**KIRKLEES METROPOLITAN COUNCIL
INVESTMENT & REGENERATION SERVICE**

Reference No: 2018/62/90332/W

Site Address: Workshop, King Cliff Road, Birkby, Huddersfield, HD2 2RR

Description: Erection of extensions and alterations to workshop to form one dwelling (within a Conservation Area)

Ground Floor Layout 1.50

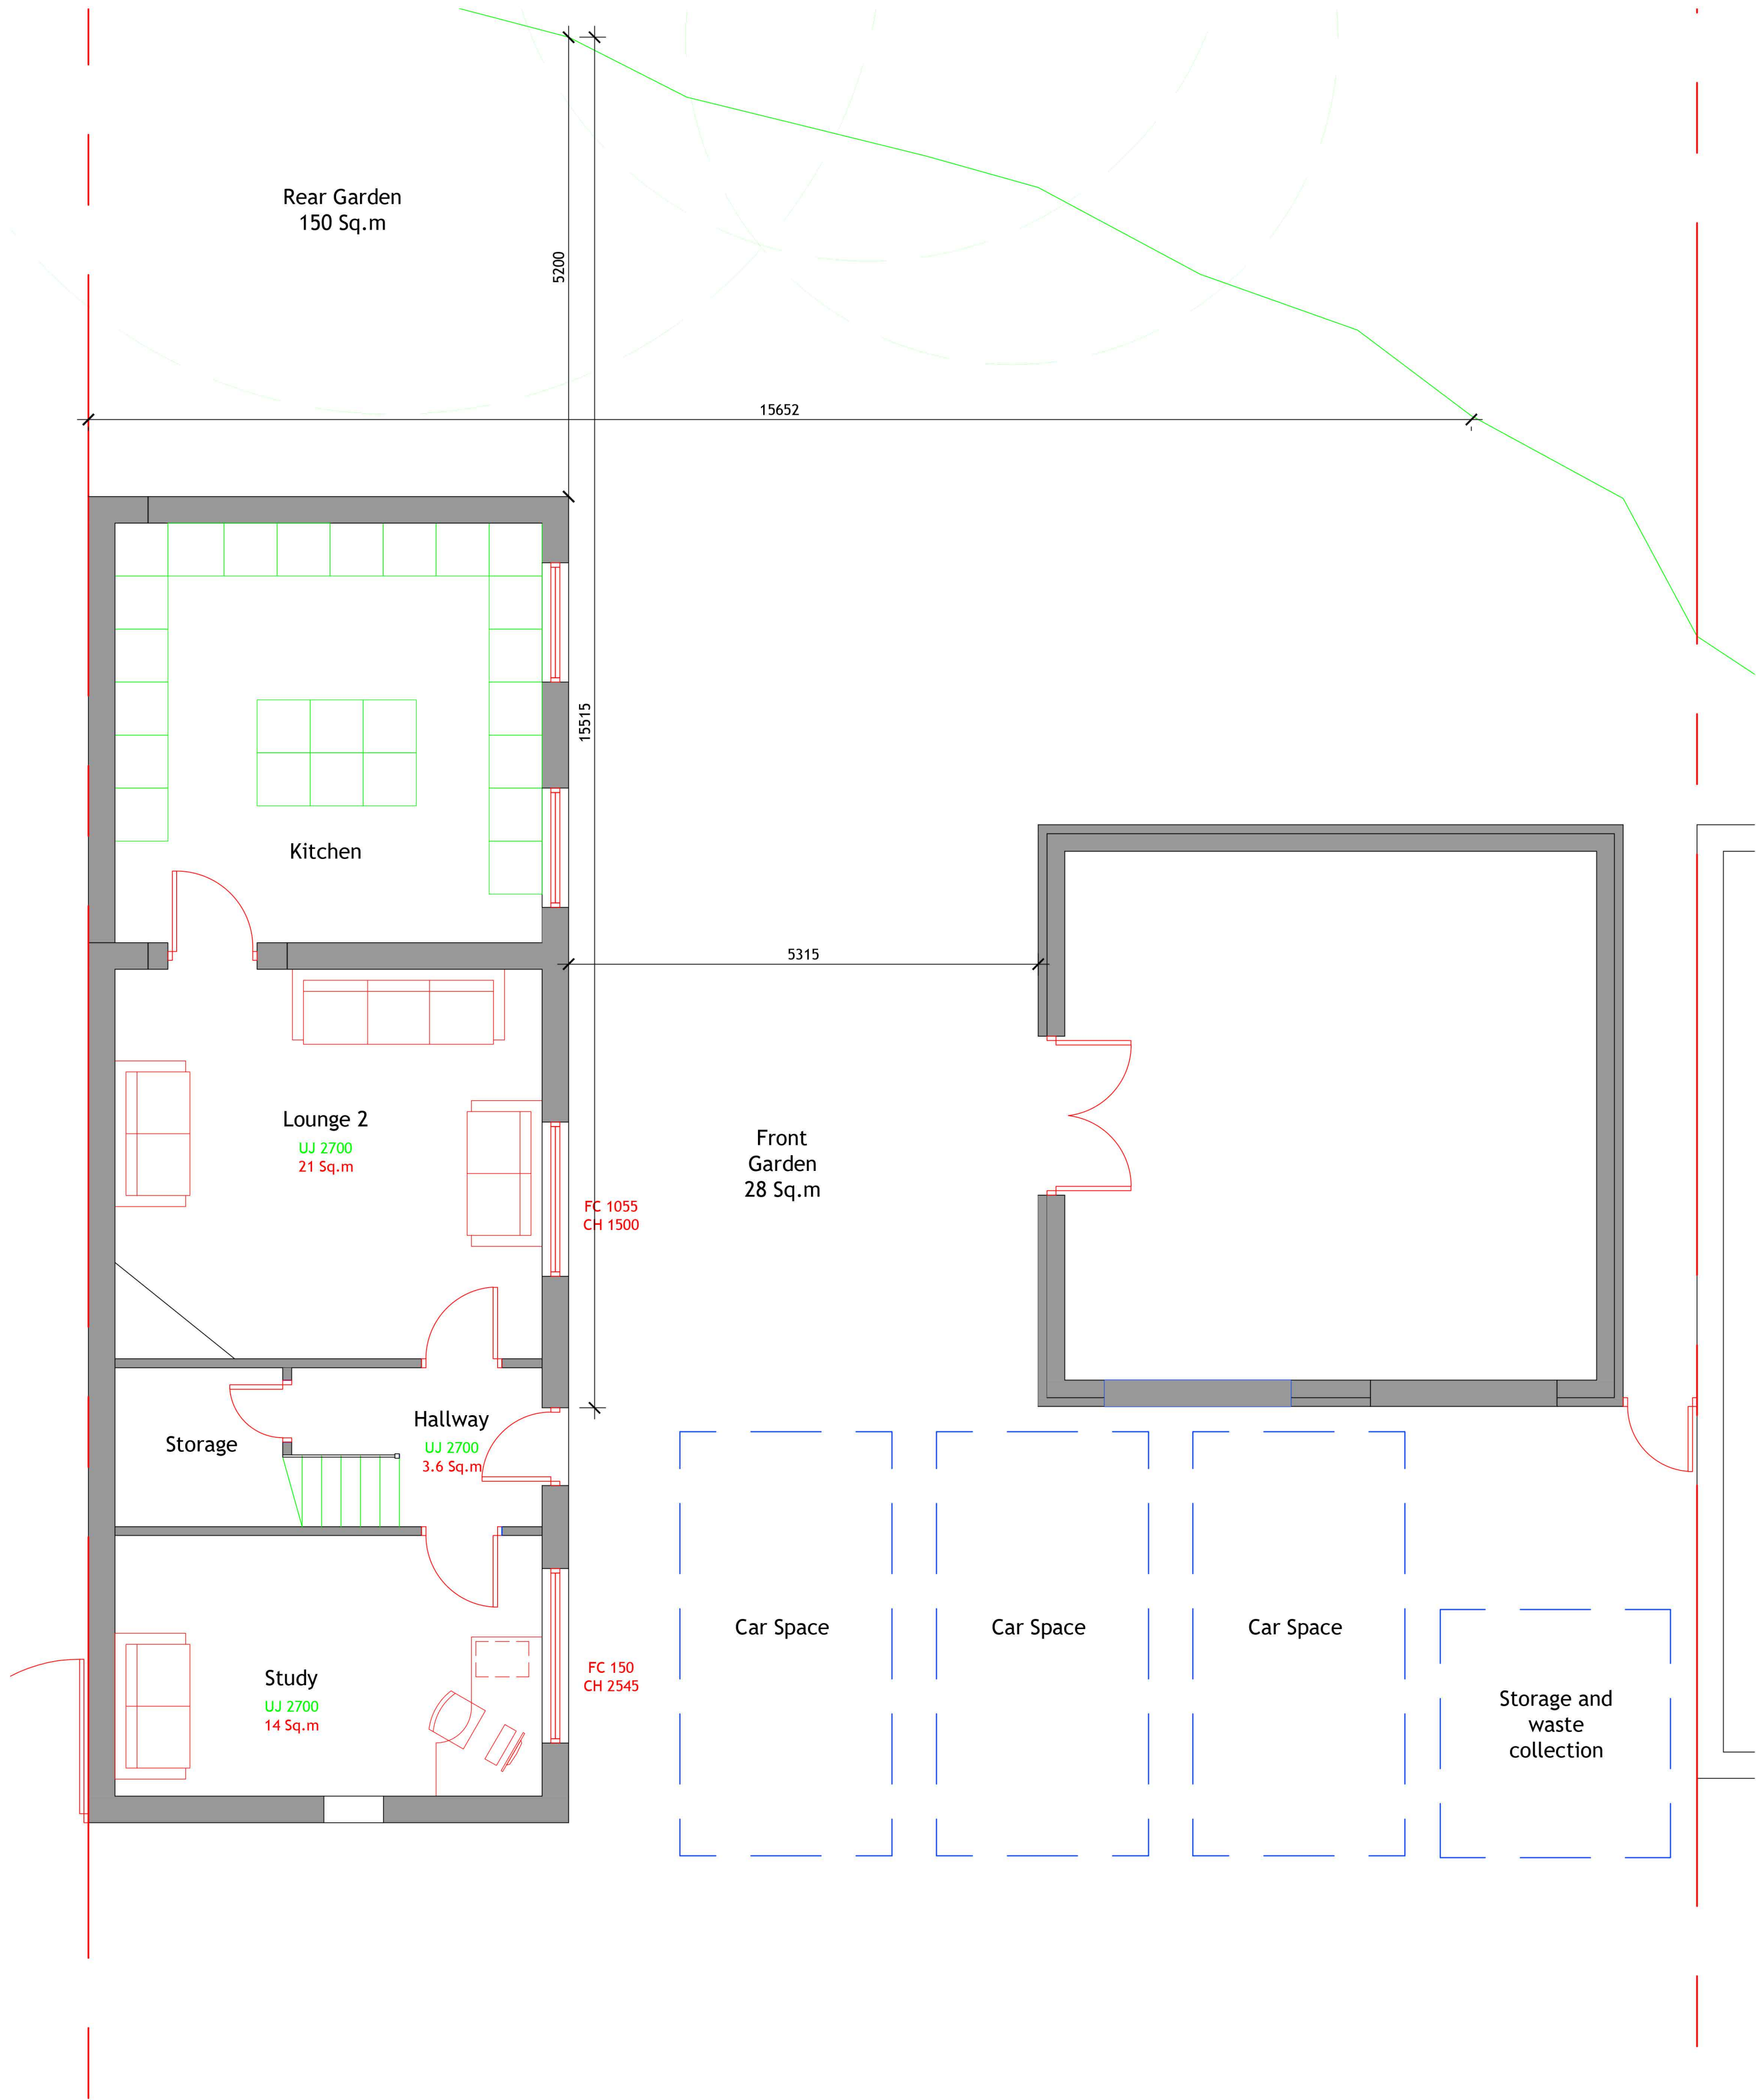
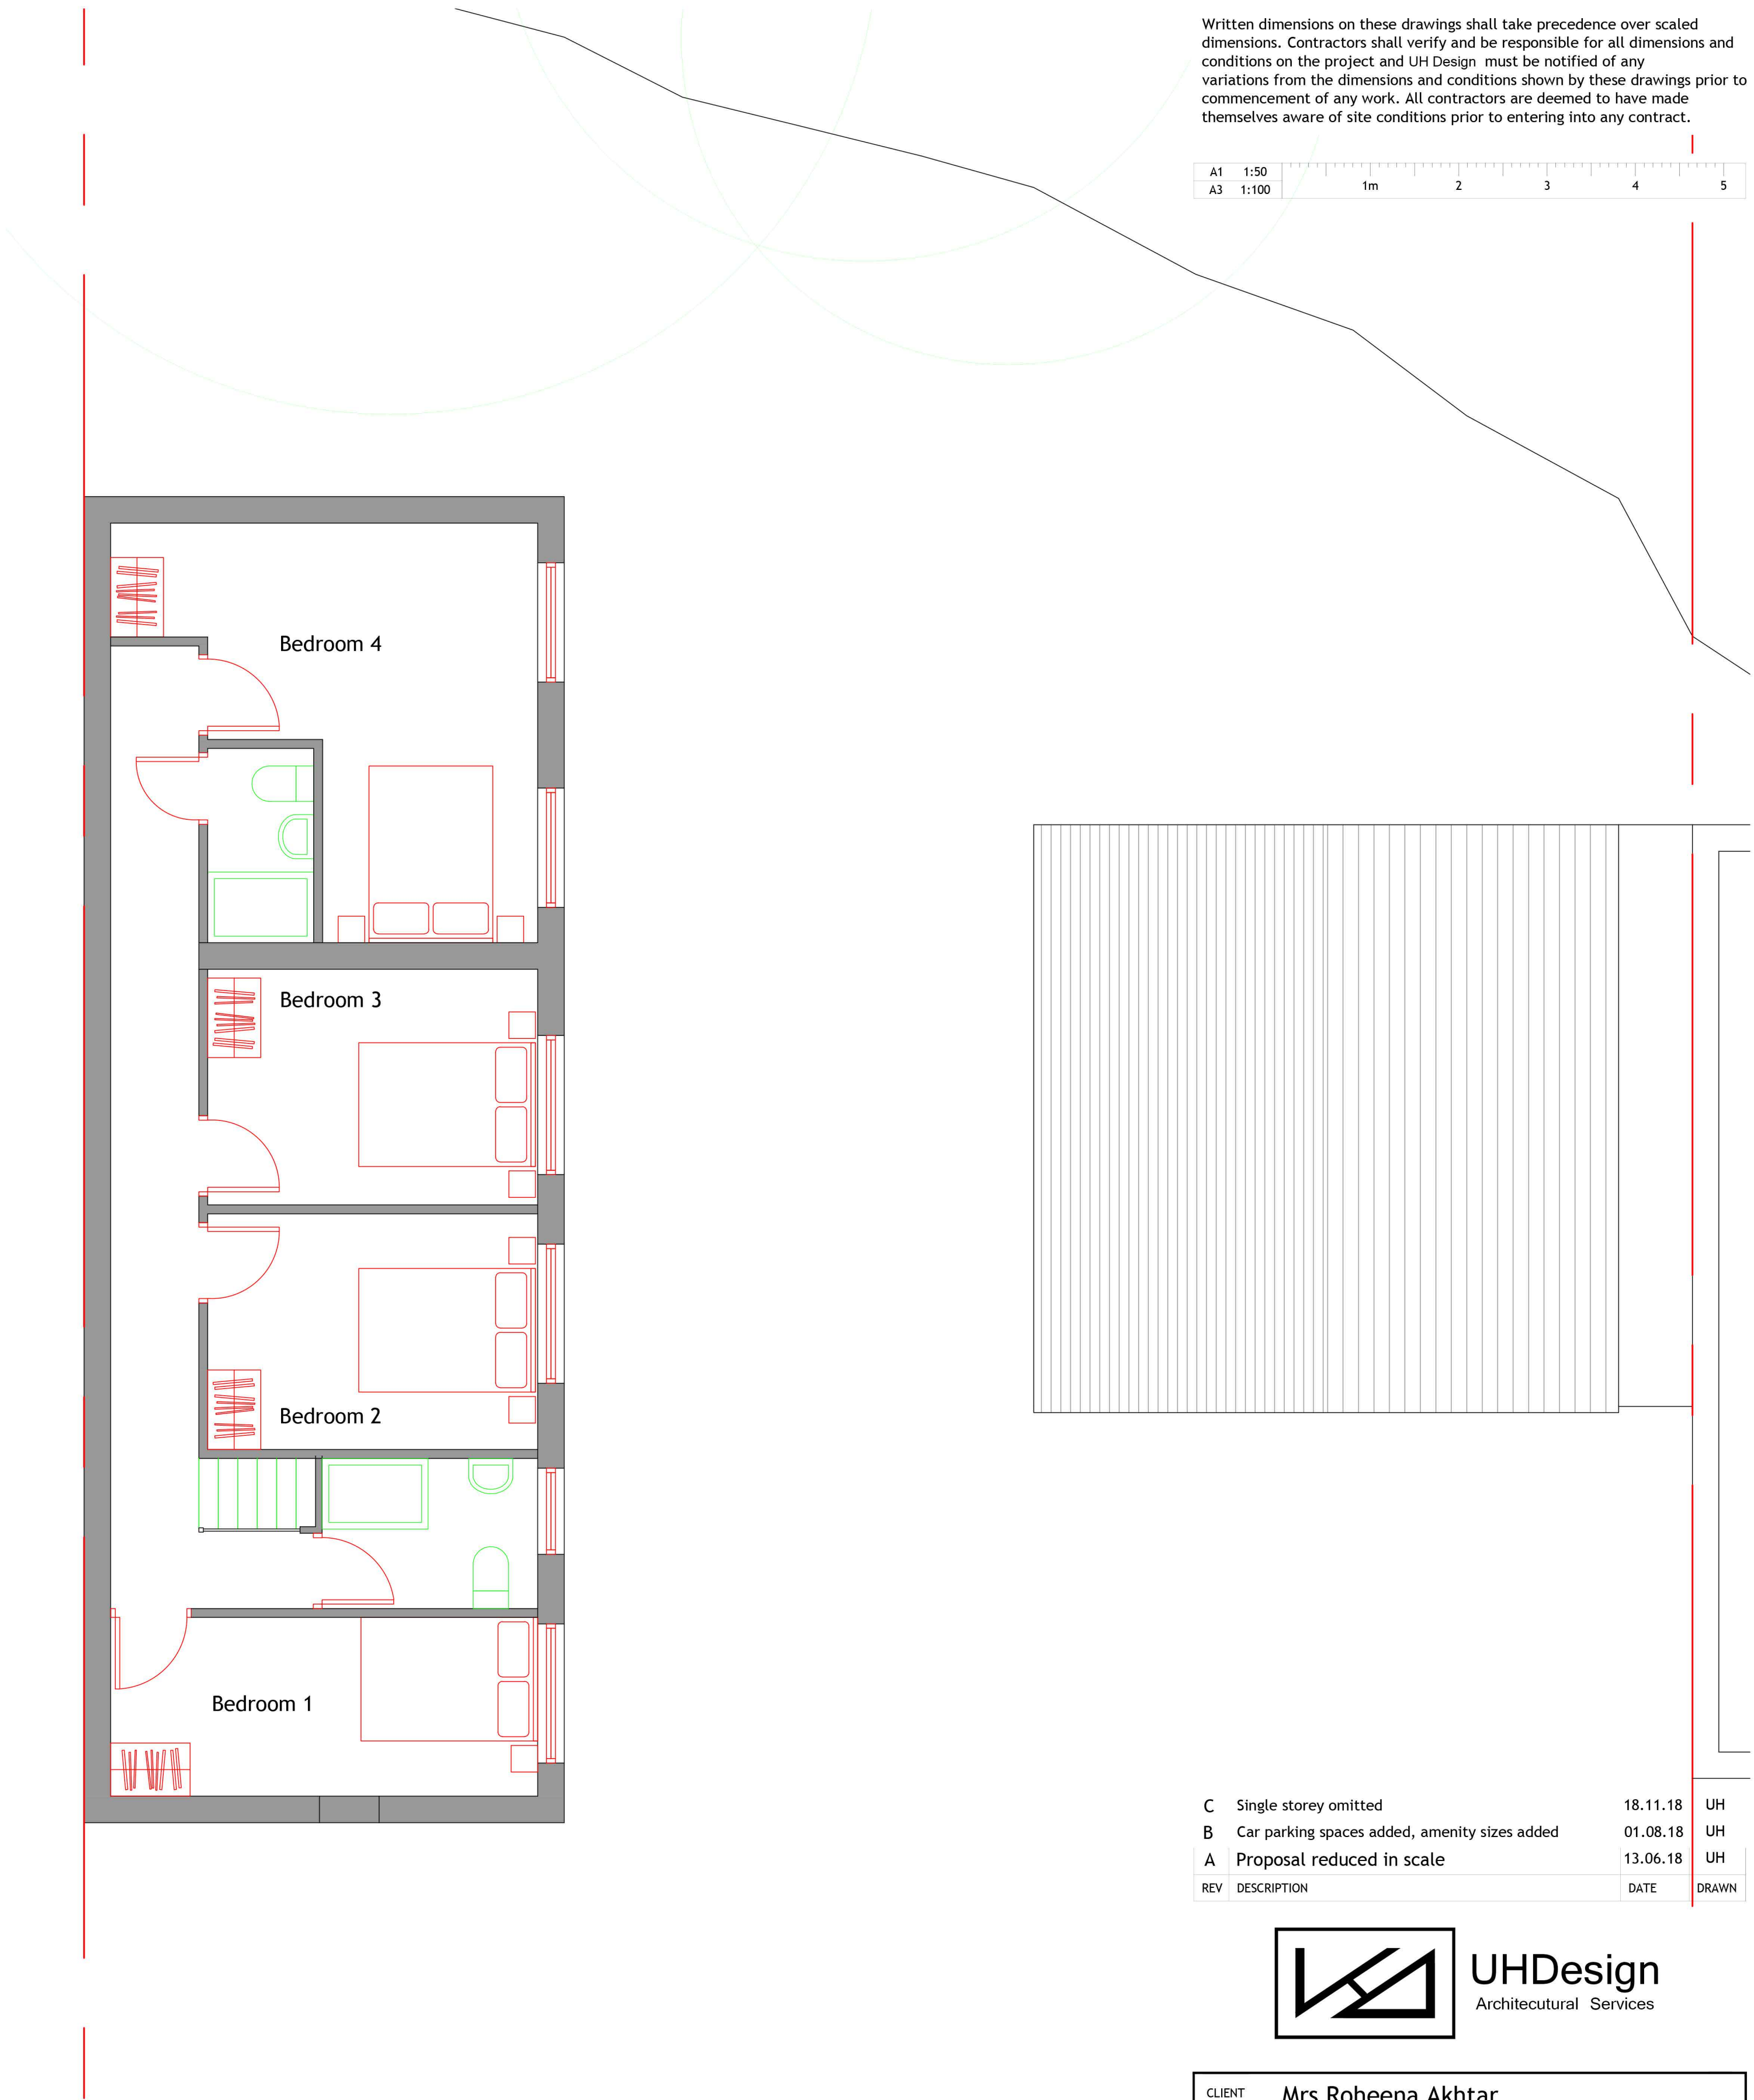
On review of the site block plan, Highway officers are satisfied that the proposals which now demonstrates on site parking for 3 vehicles, refuse storage and collection point would be accommodated and not cause causing a significant detrimental impact or harm to highway safety to the users of this and the surrounding highway network. However it is considered appropriate and necessary to impose a condition in relation to surfacing and retention of these areas to be retained for these purposes to accord with Policies D2, T10, and T19 of the UDP and PLP 21 and 22 of the DPLP.

10. An electric vehicle recharging point shall be installed within the approved storage building or parking area as shown on drawing no. 1503/02/C before the dwelling is first occupied. Cable and circuitry ratings shall be of adequate size to ensure a minimum continuous current demand of 16 Amps and a maximum demand of 32Amps. The electric vehicle charging point so installed shall thereafter be retained.
